Consultation Response from Mark Berry KC, Highways Development Management
2023/93059 Land off, Staincliffe Road, Dewsbury Moor, Dewsbury, WF13 4RD
Erection of light industrial units
Date Responded: 7-3-2024. Responding Officer: Mark Berry. Responding Ref: 14-6NE-25.
This application seeks approval to the erection of 3 small light industrial units at land off, Staincliffe Road, Dewsbury Moor, Dewsbury. The site comprises of an area of land situated on the southern side of Bronte Close which is a residential cul-de-sac with footways to both sides and a small turning head. A PROW runs along the northern boundary of the site boundary of the site leading through to Dewsbury Hospital. There are double yellow lines to both sides of Bronte Close from the Junction with Staincliffe Road and past the site frontage (presumably because of people parking for the hospital). The application is supported by a Highways Statement prepared by Paragon Highways. This considers such matters as access, sustainability, car parking, accident data and servicing. The traffic impact associated with the current development proposals is also presented. This is summarised as follows: <i>“The site will be accessed

1 PROPOSED SITE PLAN
1 : 200

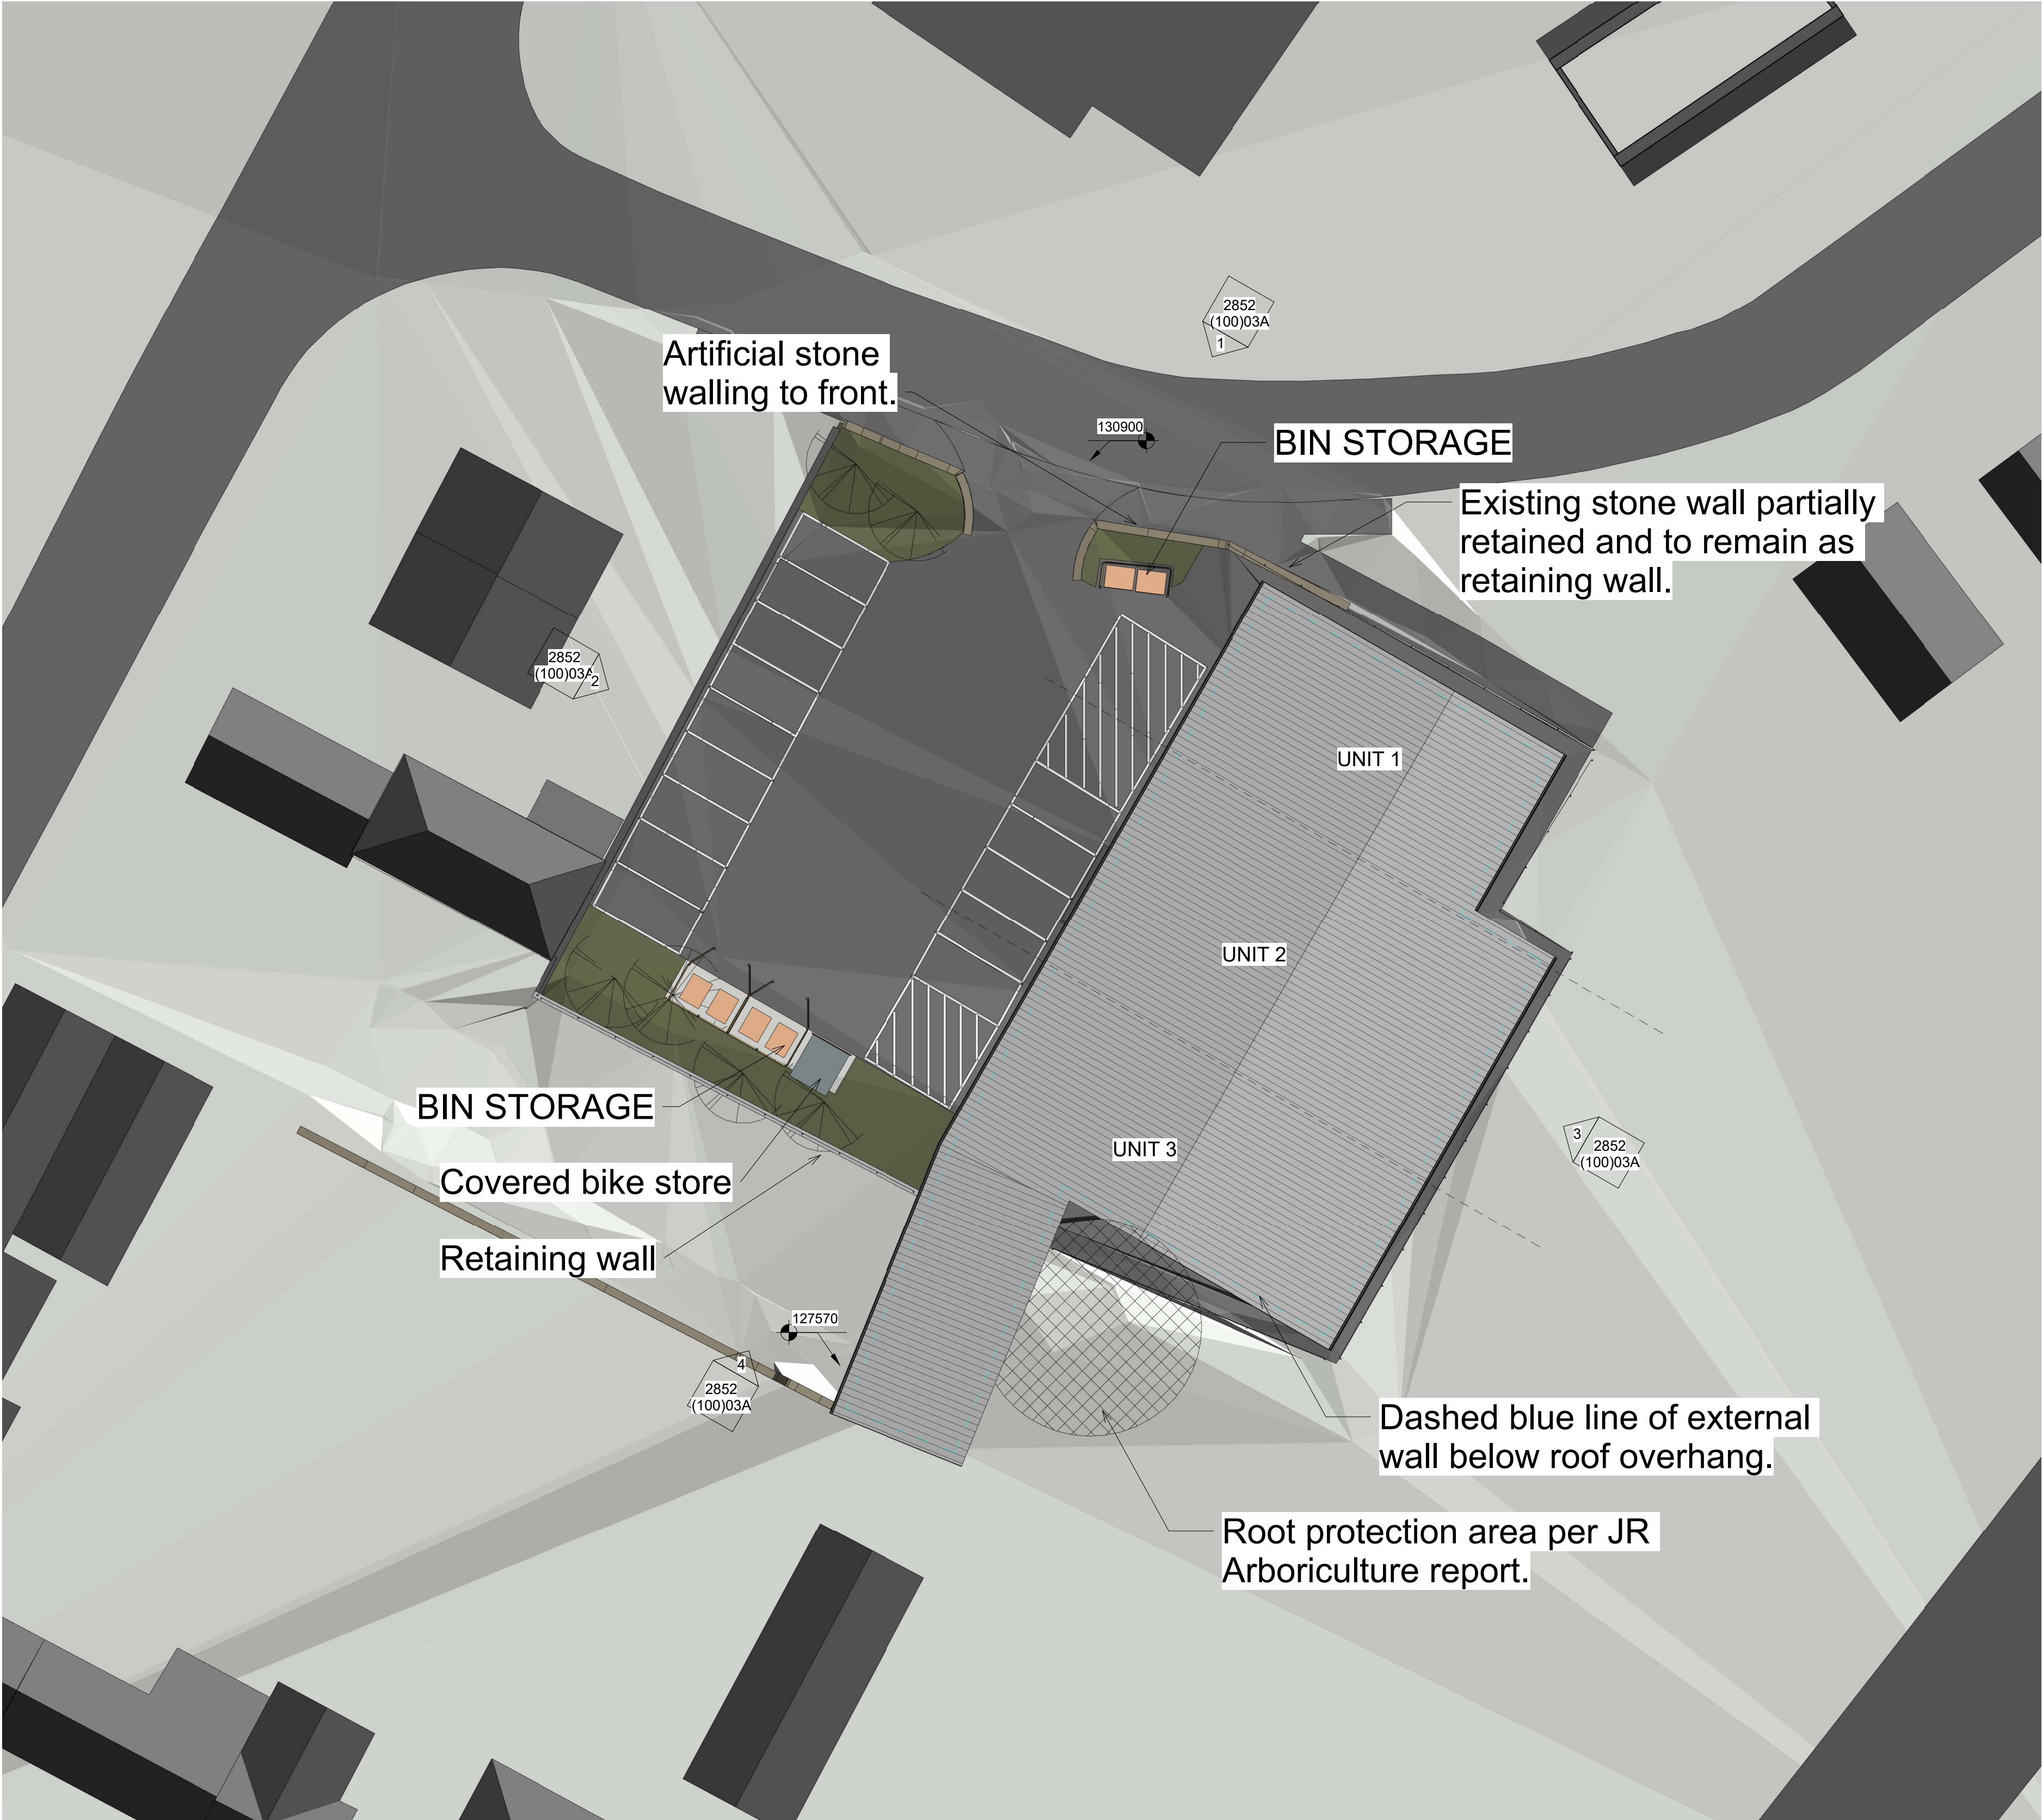
No information is provided regarding the servicing arrangements. Vehicle swept paths should be provided showing how this site can be safely serviced including:

A, 16.5m articulated lorry and a larger rigid vehicle on Bronte Close presumably using the site entrance.

B, the largest vehicle anticipated to regularly enter and exit the proposed development.

PROJECT TITLE						
STAINCLIFFE ROAD, DEWBURY						
DRAWING TITLE						
VEHICLE TRACKING – 16.5M MAX LEGAL ARTIC						
DRAWING NUMBER						
ORIGINATOR	PROJECT	VOL.	TYPE	ROLE	NUMBER	
PRGN - 2221	HGN	DR	CH	0002A		
CLIENT						
ACUMEN DESIGNERS & ARCHITECTS						
SCALE						
1:500	A3	JJH	LJO	JJH	MAR 24

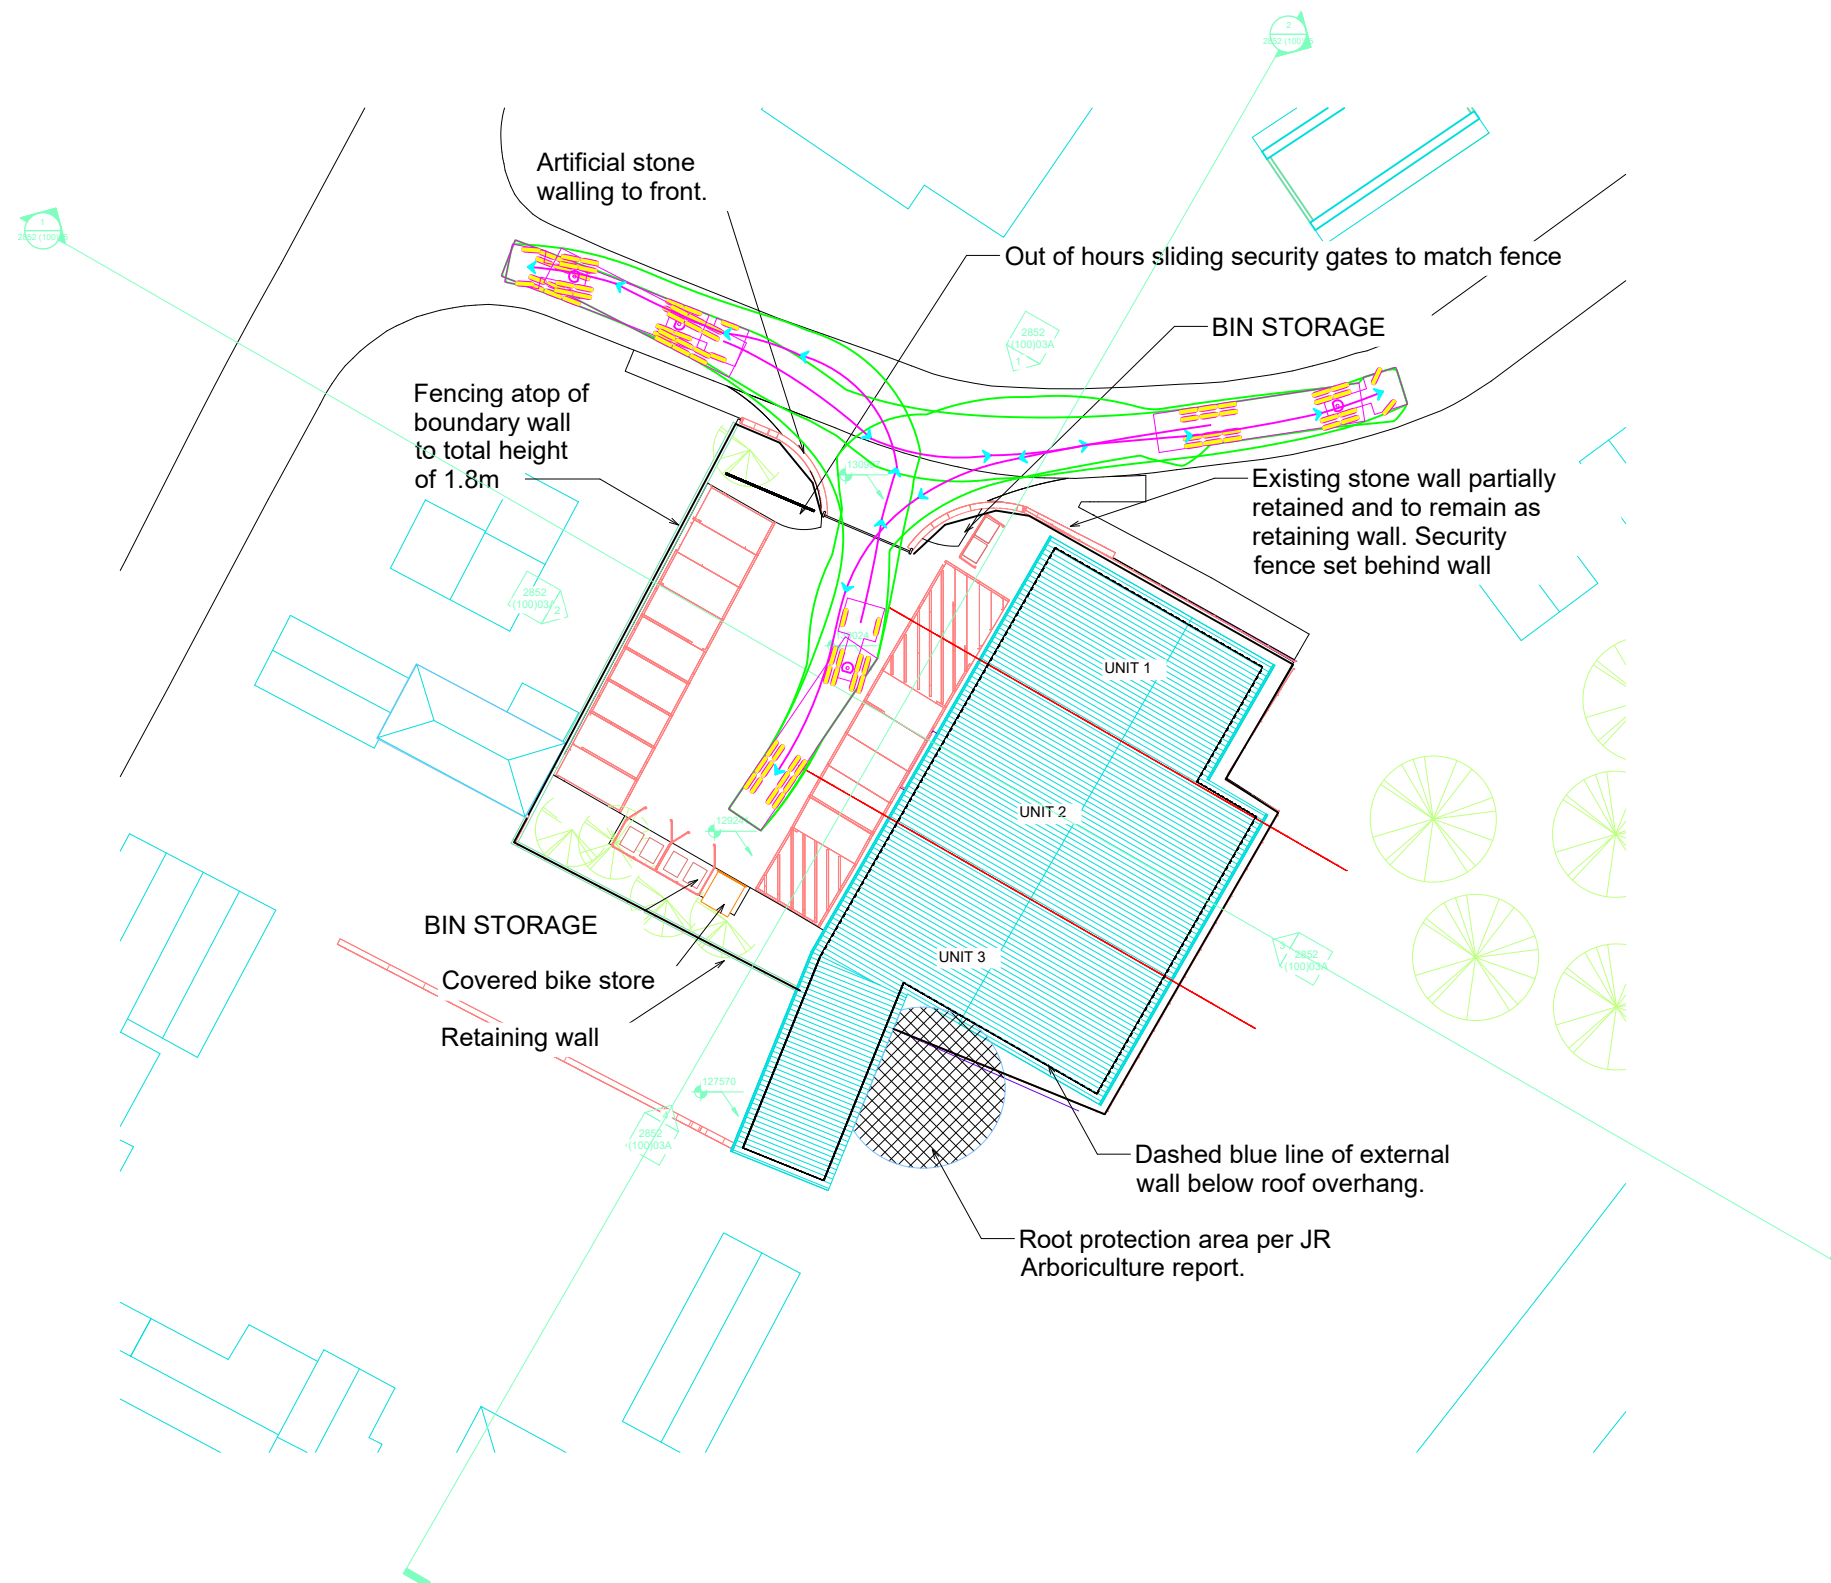
be unacceptable for a larger vehicle such as a 16.5m articulated lorry or a larger rigid vehicle to need to reverse back out of the Staincliffe Road junction and the Bronte Close turning head is unlikely to be suitable at approximately 12 metres in width.
